11/08/2020

**St Francis College Stage 1 - Landscaping (SSD-10365)  
Response to Submissions**

SECTION A

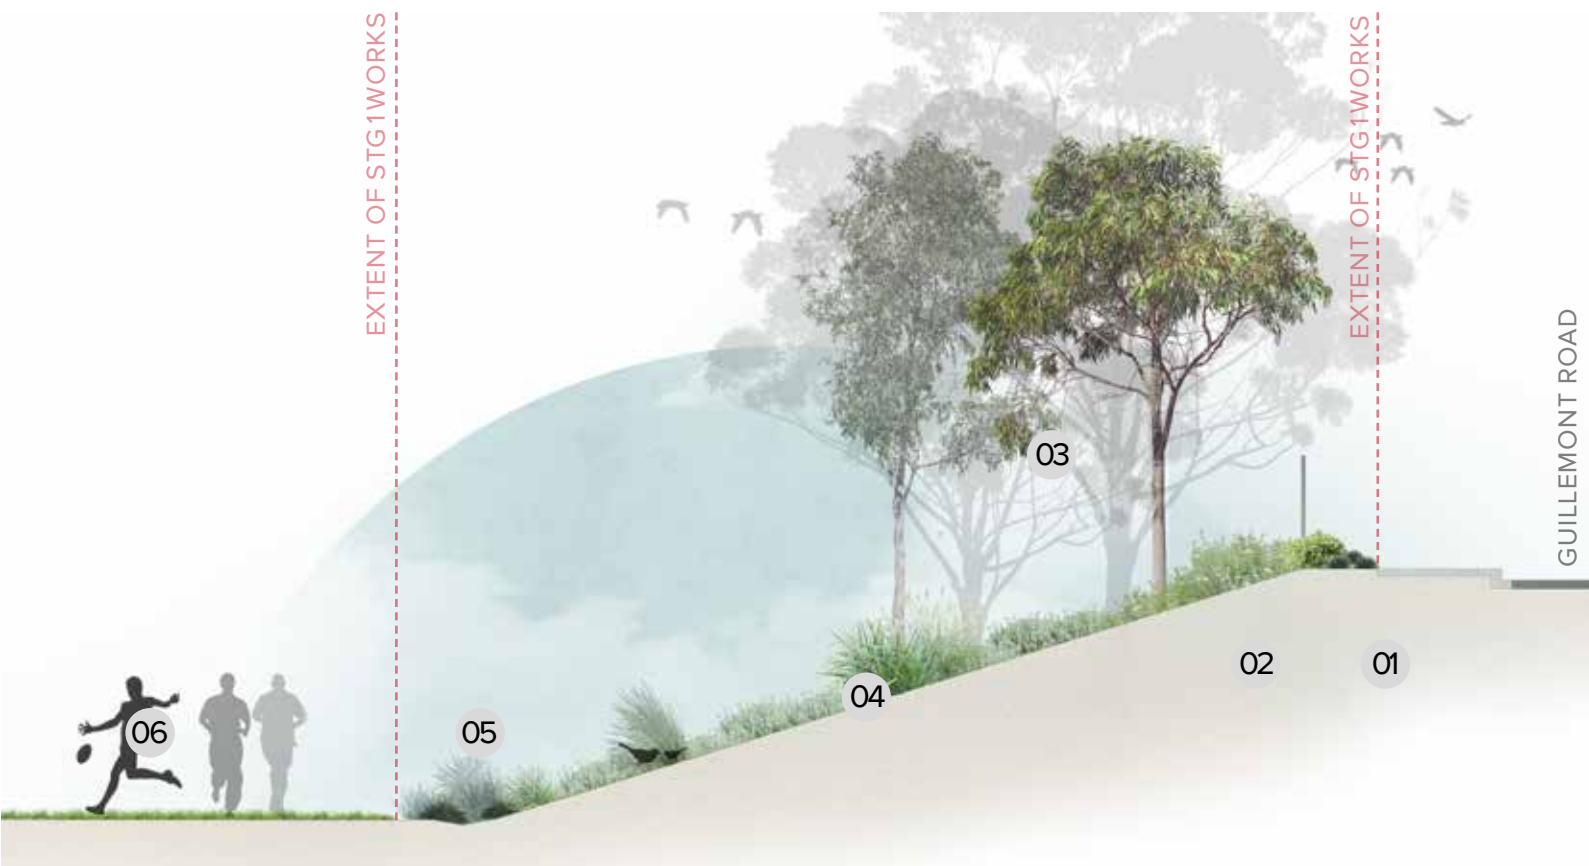
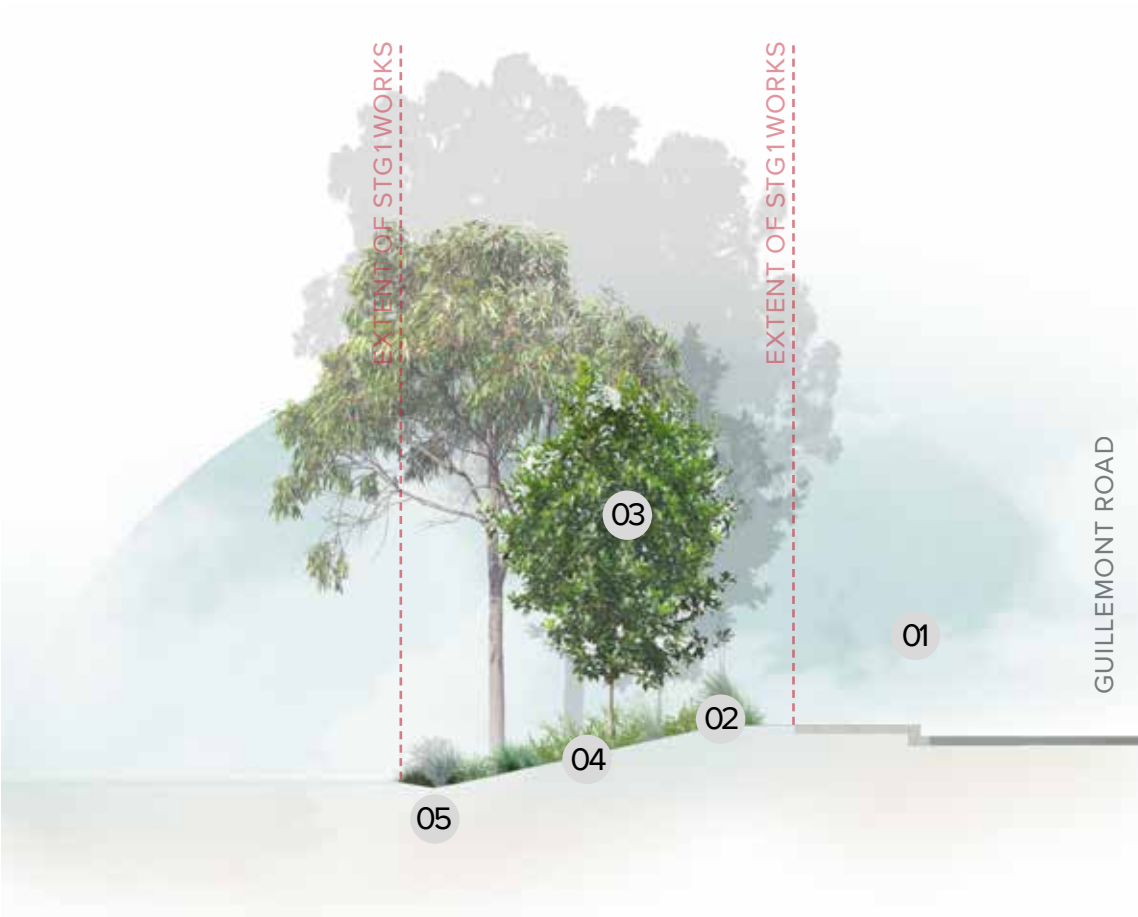
- The submitted Proposed Site Plan (reference: 1130 SSD11 Rev 01; dated: 11/02/2020) includes reference to a new fence, which is not shown on other submitted drawings. Existing and proposed elevation drawings should be submitted to provide clarity regarding the proposed works for which approval is sought.

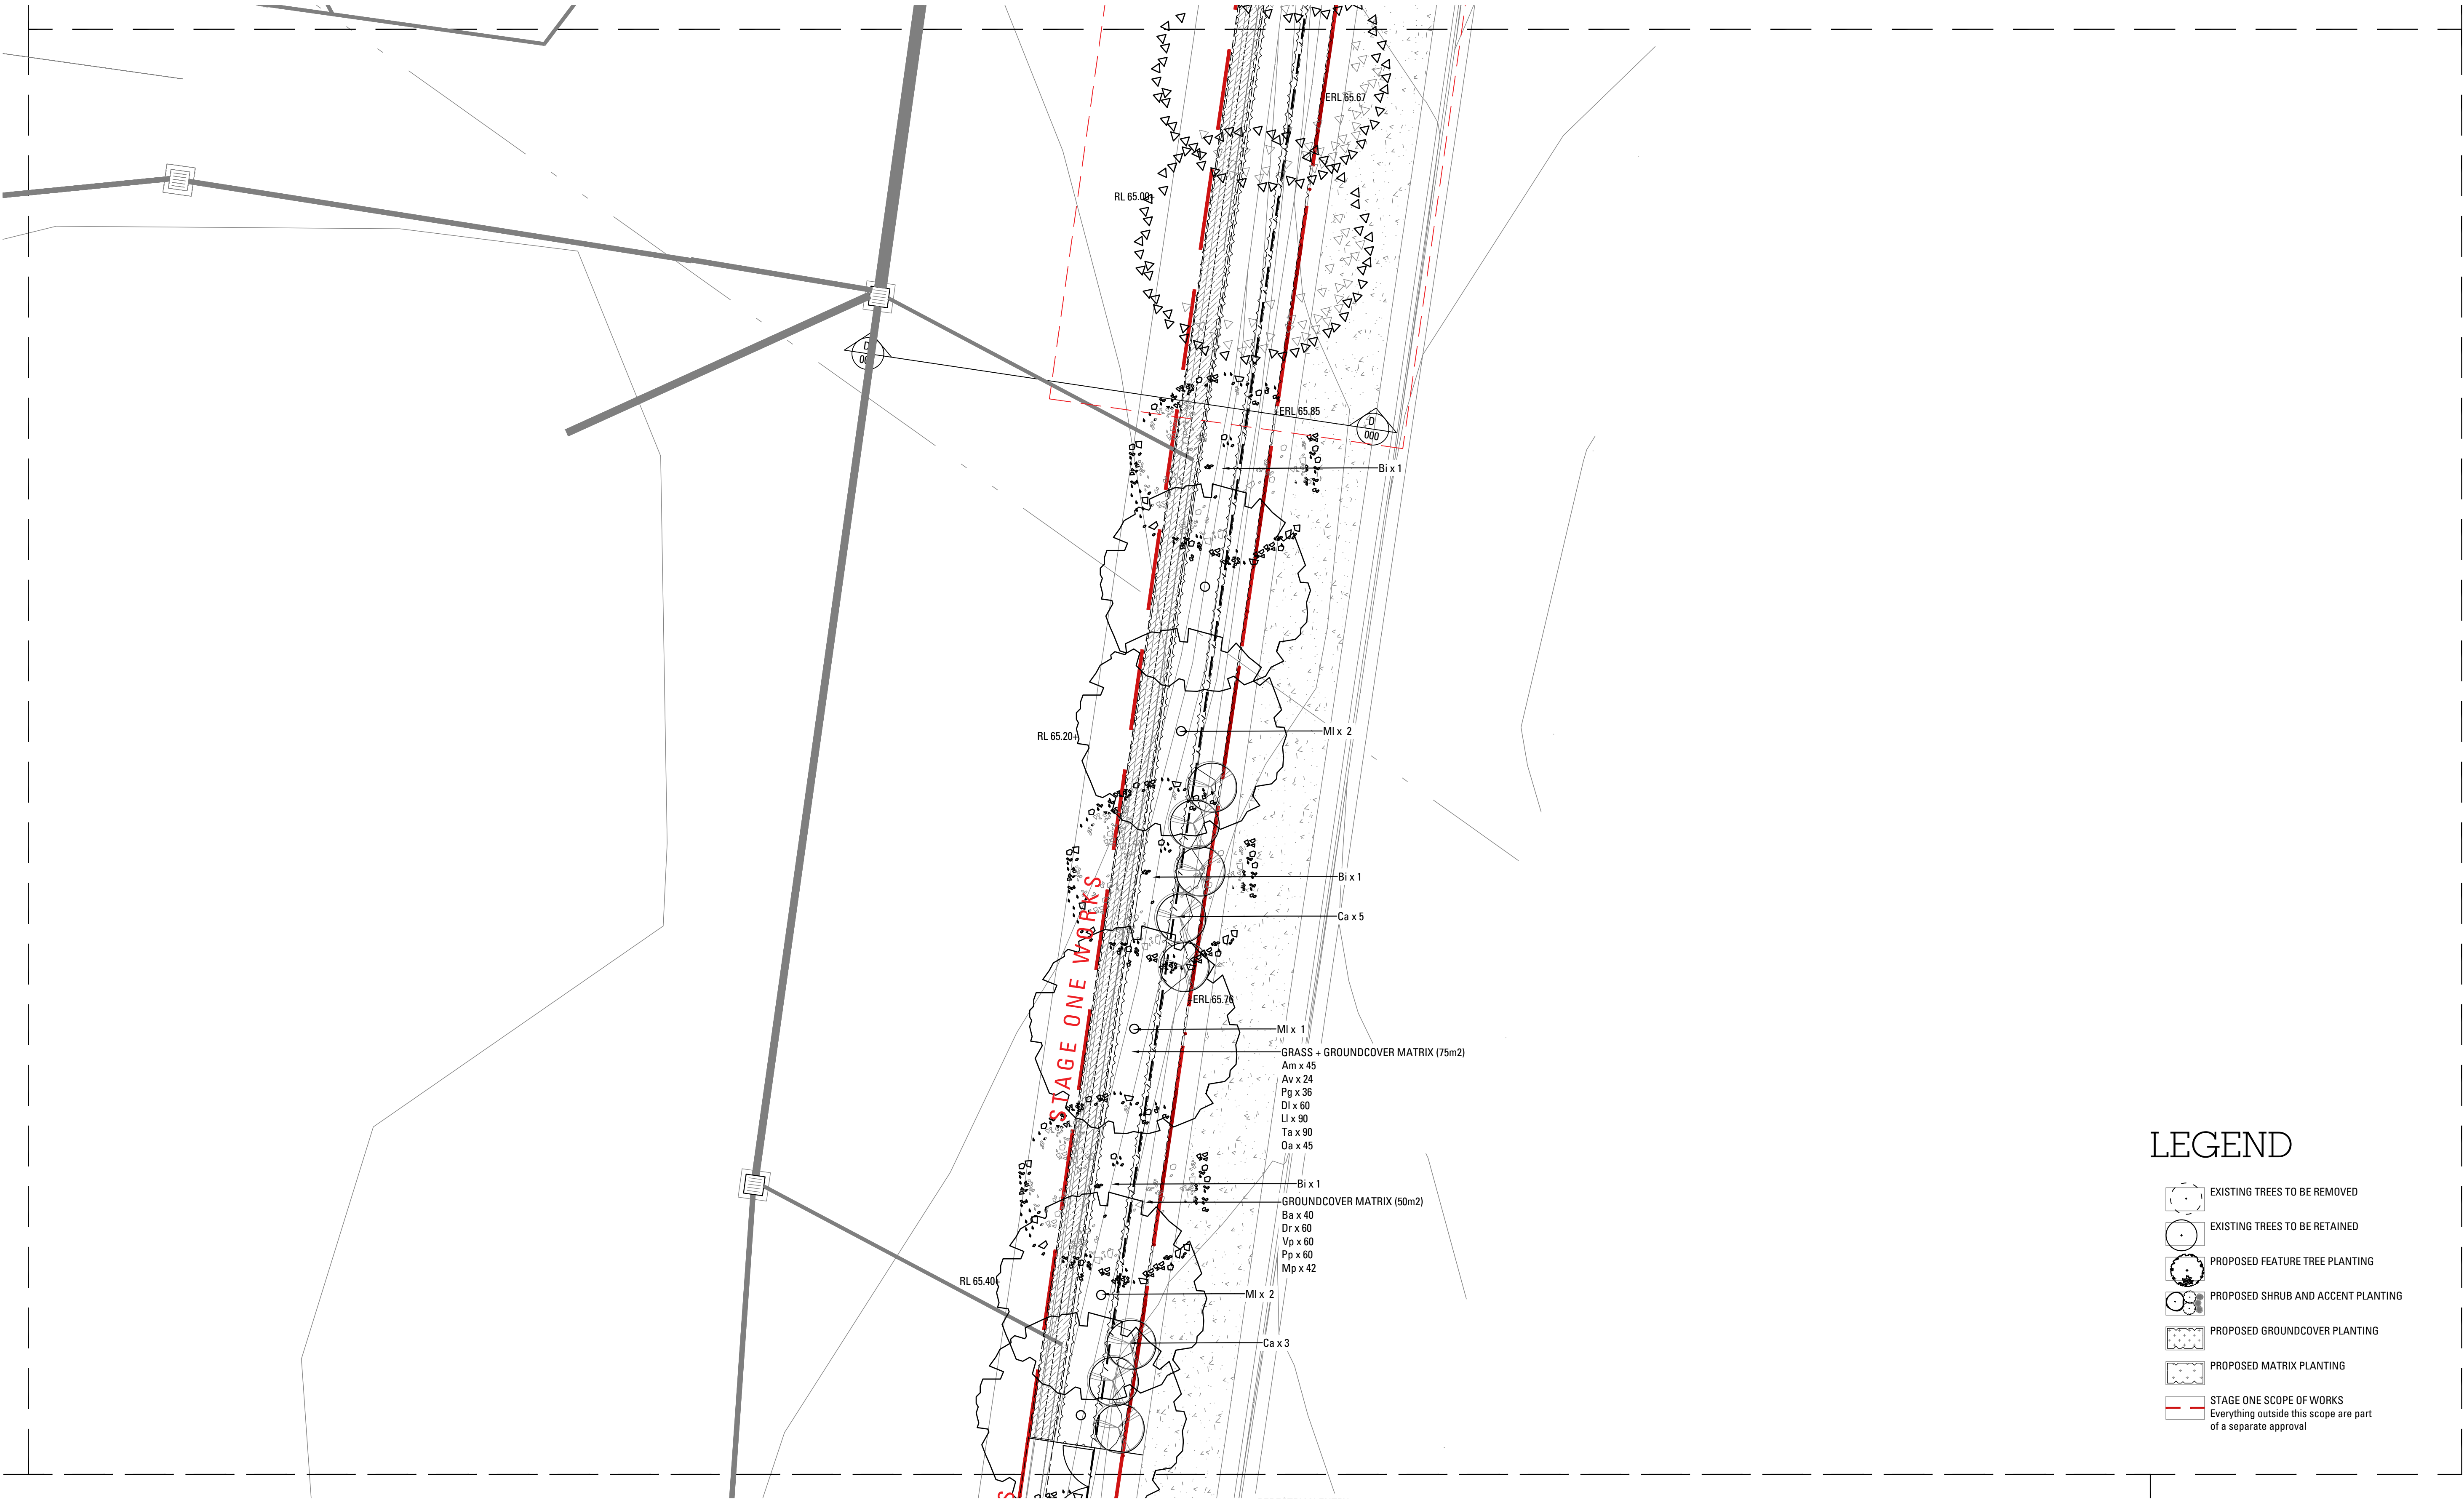
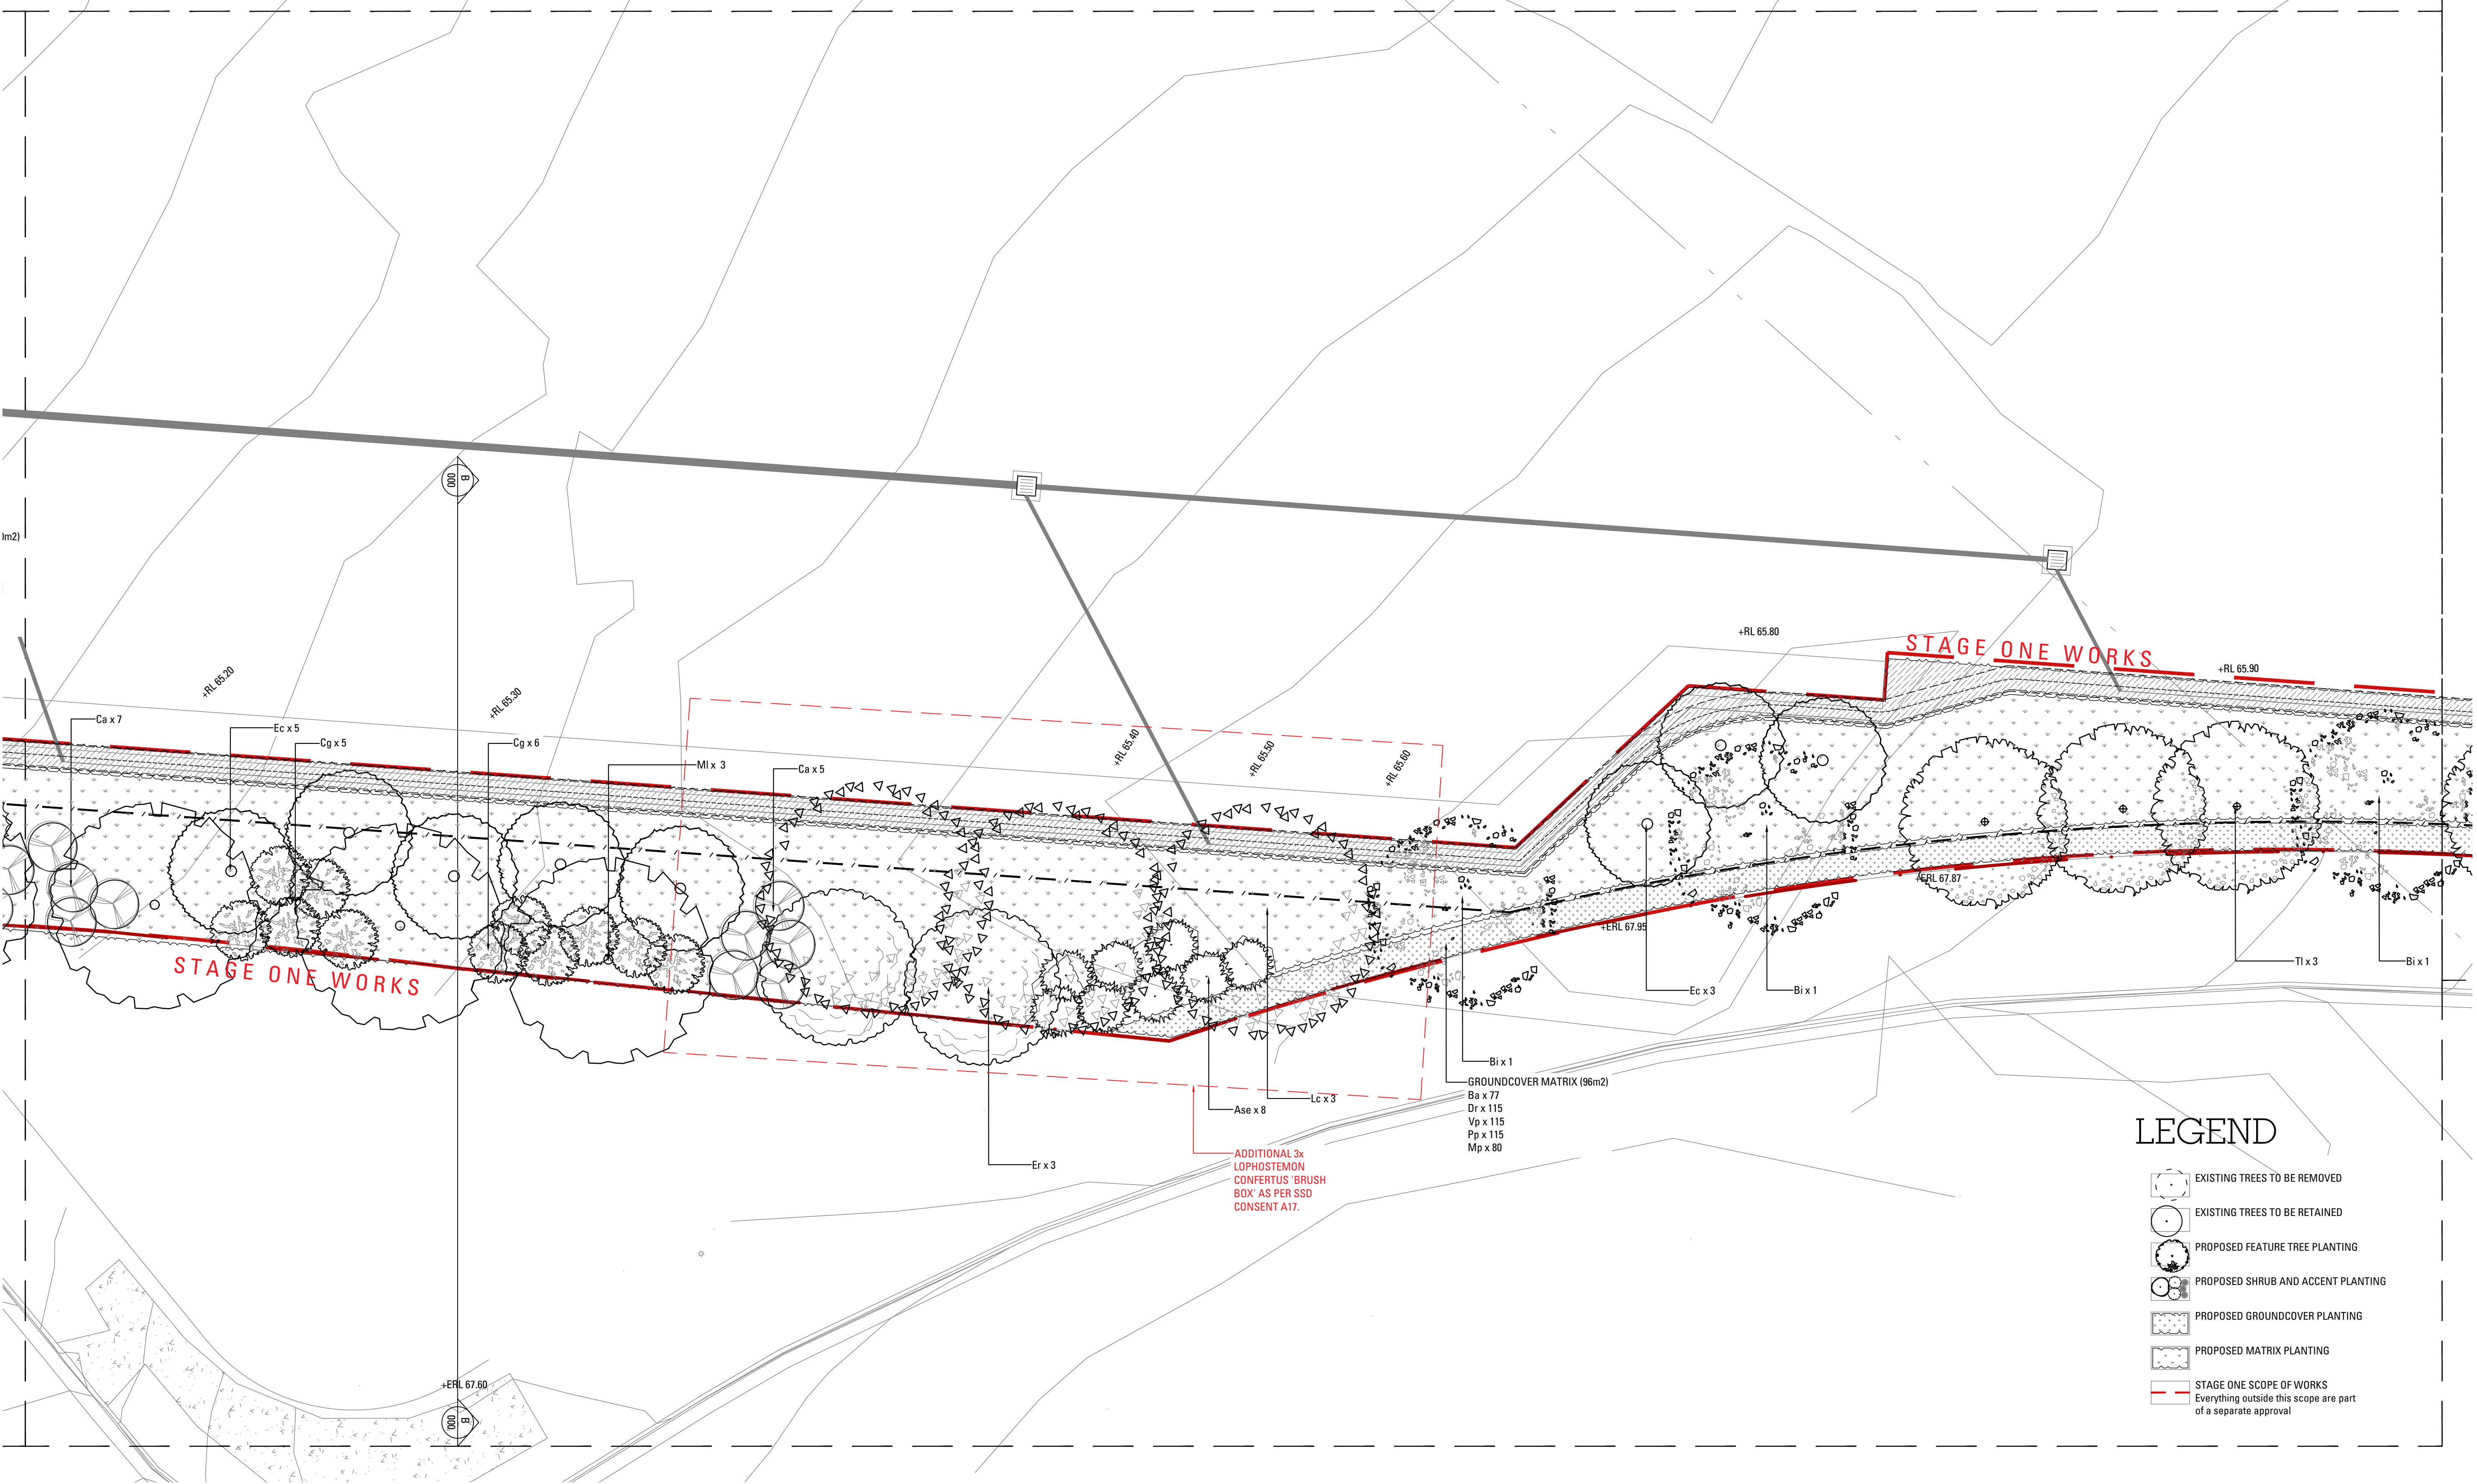
- The submitted Proposed Site Plan (reference: 1130 SSD11 Rev 01; dated: 11/02/2020) does not clearly identify the development footprint for which approval is sought under this development application. Plans intended for approval need to clearly identify the proposed development footprint for Stage 1. Any works falling outside of the development footprint would require a separate consent and would be treated as indicative only. It is suggested that an appropriate key be used to distinguish and identify Stage 1 works from other works shown on the plan for context
